CITY OF ALBUQUE

July 19, 2022

Re: Restaurant Depot – 1901 Menaul Blvd. NE
ESC Plan Engineers Stamp Date: Missing – (H15E039)

Drawing file: Old plans / C500 Erosion Plan.pdf

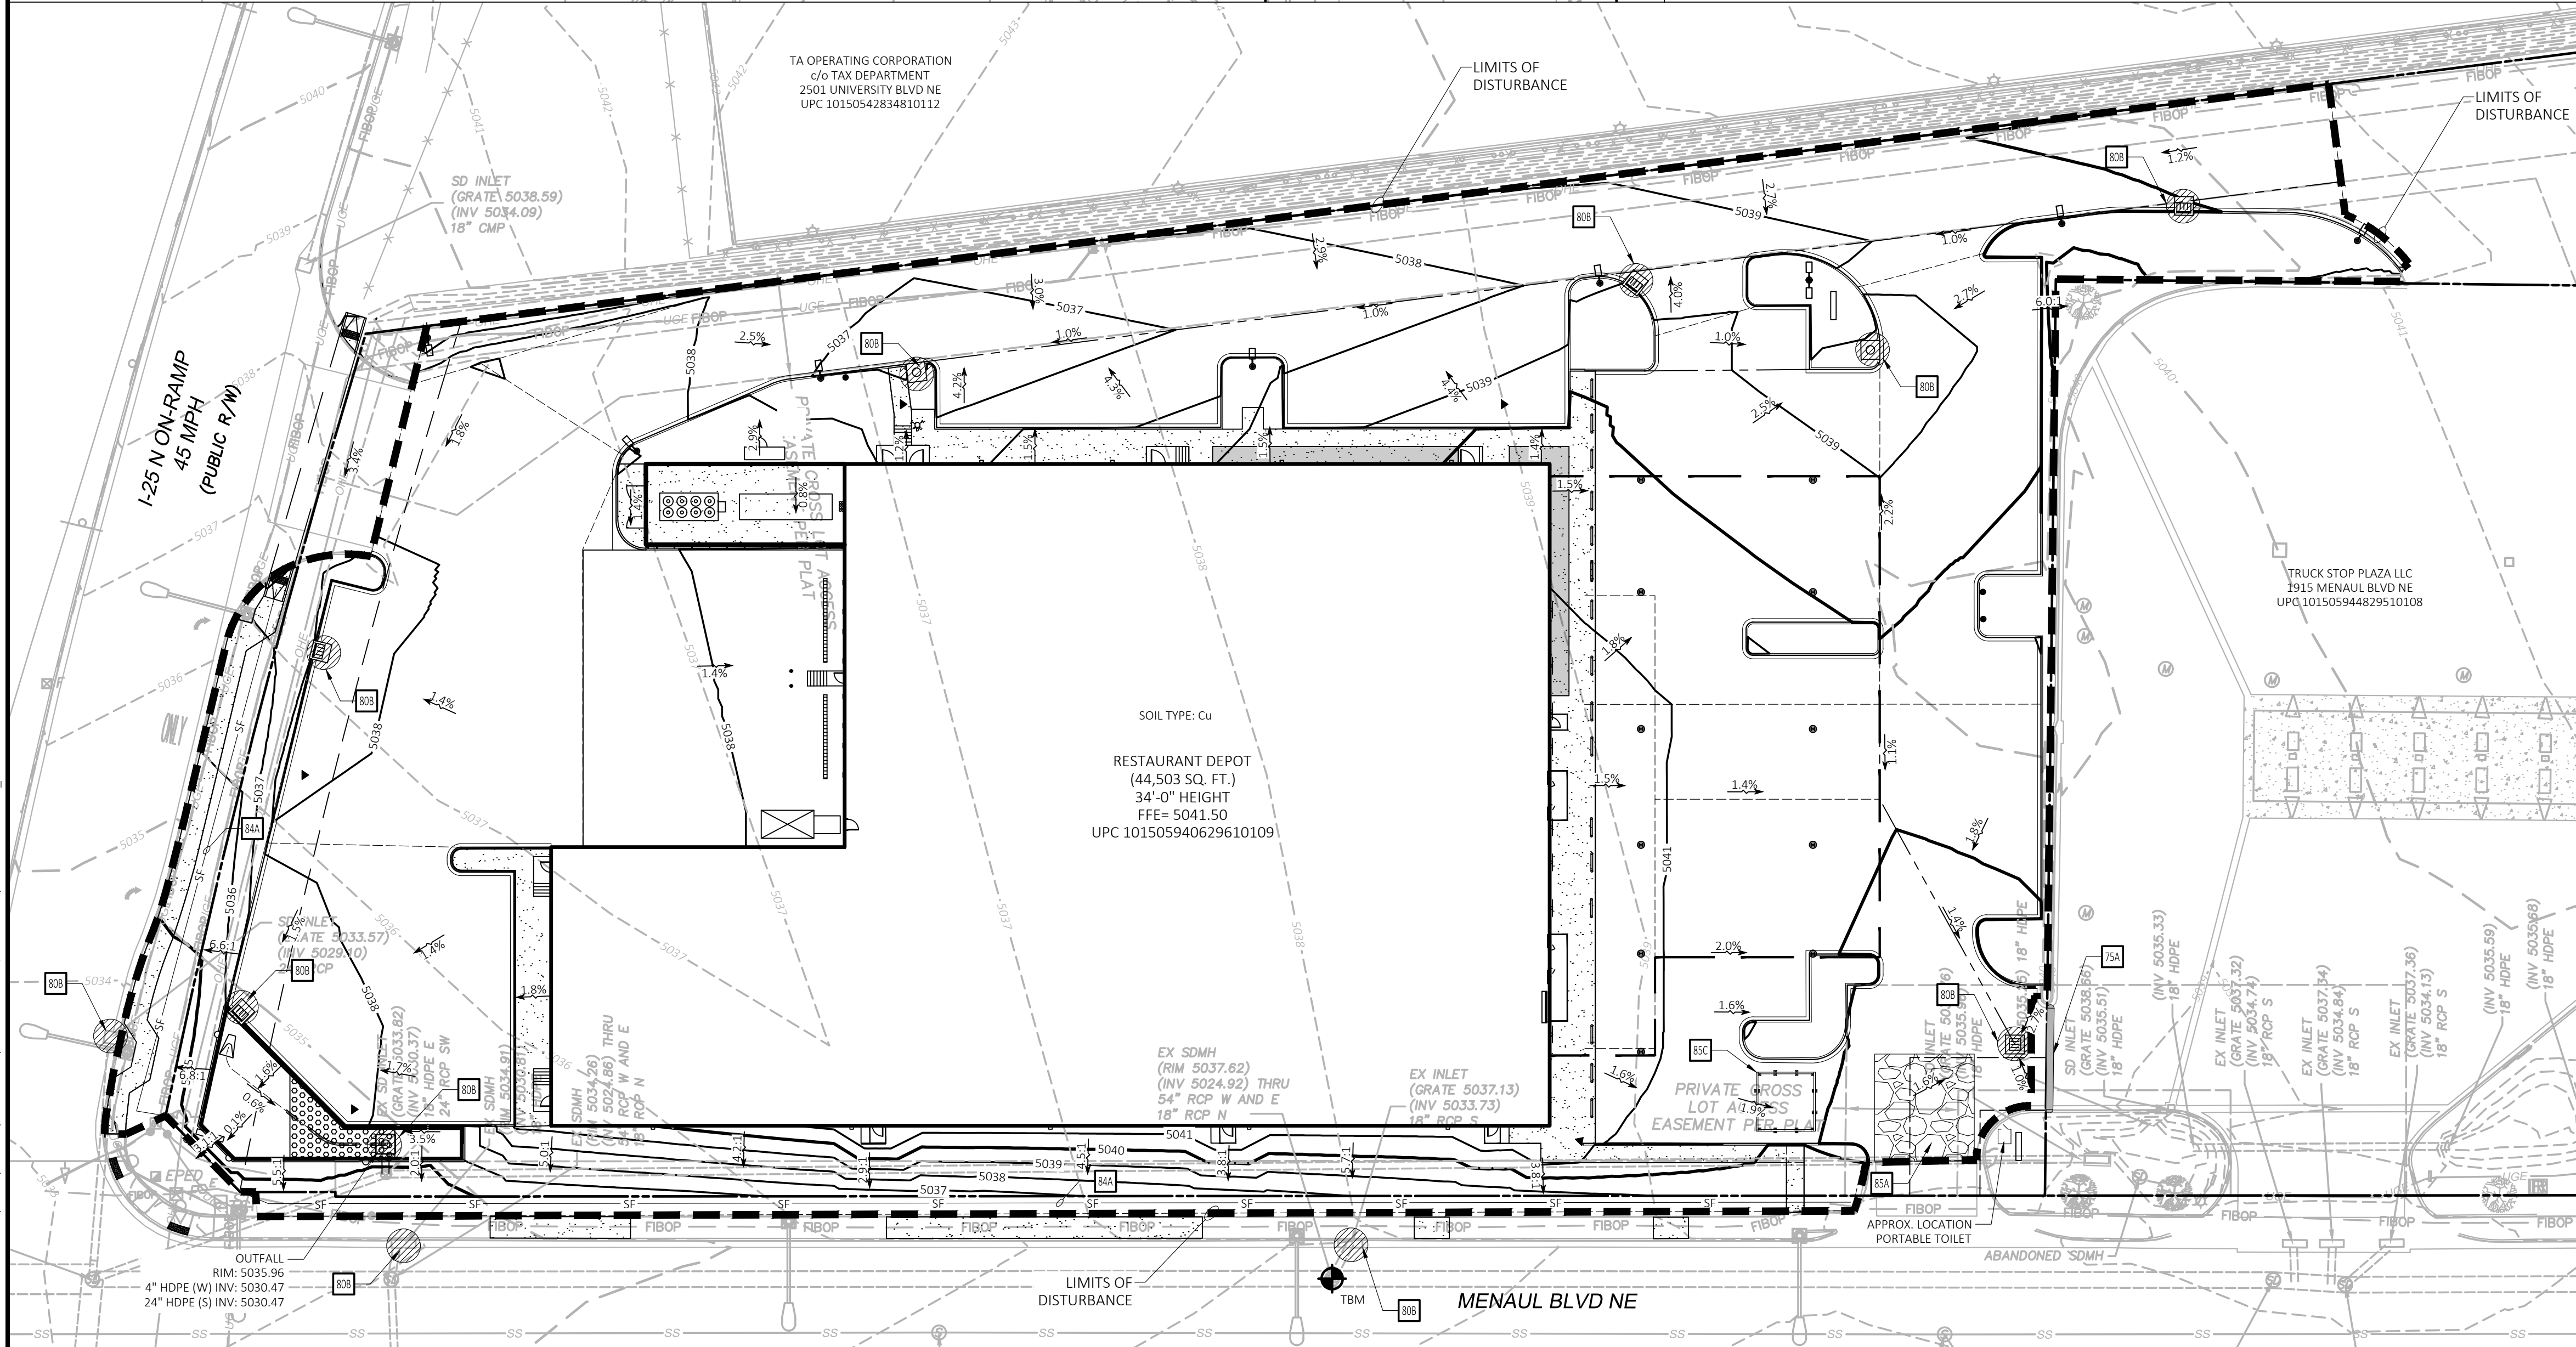
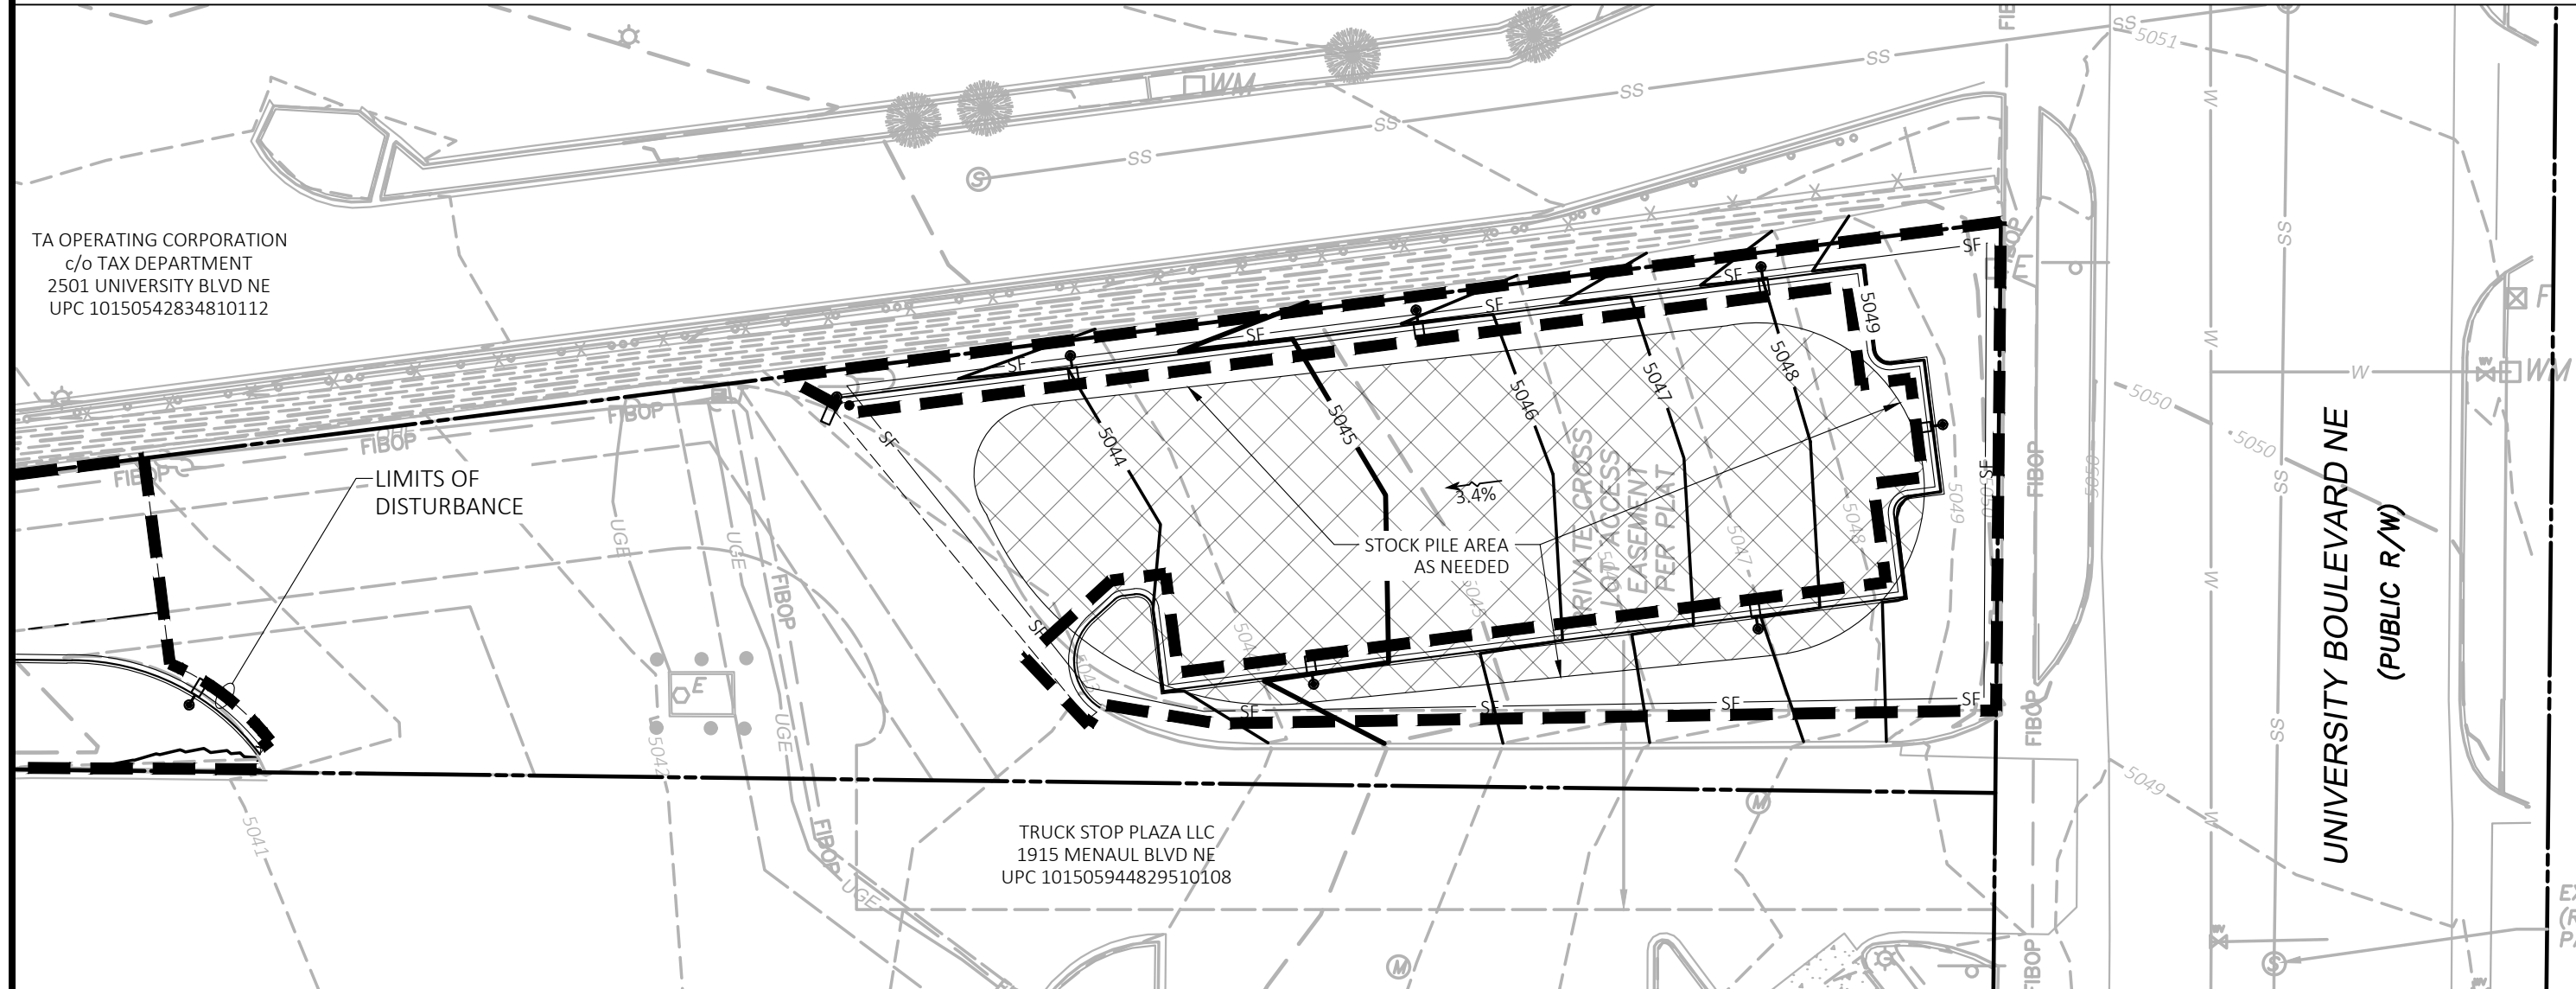
1. The ESC Plan can't be approved until after Hydrology approves the G&D Plan. The existing and proposed grades must be shown on the ESC Plan, and they must agree with the Grading Plan approved by Hydrology (CGP7.2.4.b.ii).

3. I can't tell the difference between building, sidewalk, asphalt, and dirt on the ESC Plan. These structures must be clearly identified in the SWPPP per CGP 7.2.4.b.vi. The same information is required in the ESC Application. You may attach a copy of the Site Plan to both the SWPPP and the ESC Application to address this requirement.
4. The SWPPP must include site-specific interim and permanent stabilization per CGP 9.4.1.c.i. The Landscape Plan can be used to satisfy this requirement and should be submitted separate from the ESC Plan with the application to the Stormwater Quality Section of the Planning Department and they should be included in the SWPPP. Provide a specification on the ESC Plan for any disturbed areas not covered by the Landscape Plan.
5. The ESC Plans must be certified by a PE or CPESC. Update the professional's stamp date each time the plan is changed.
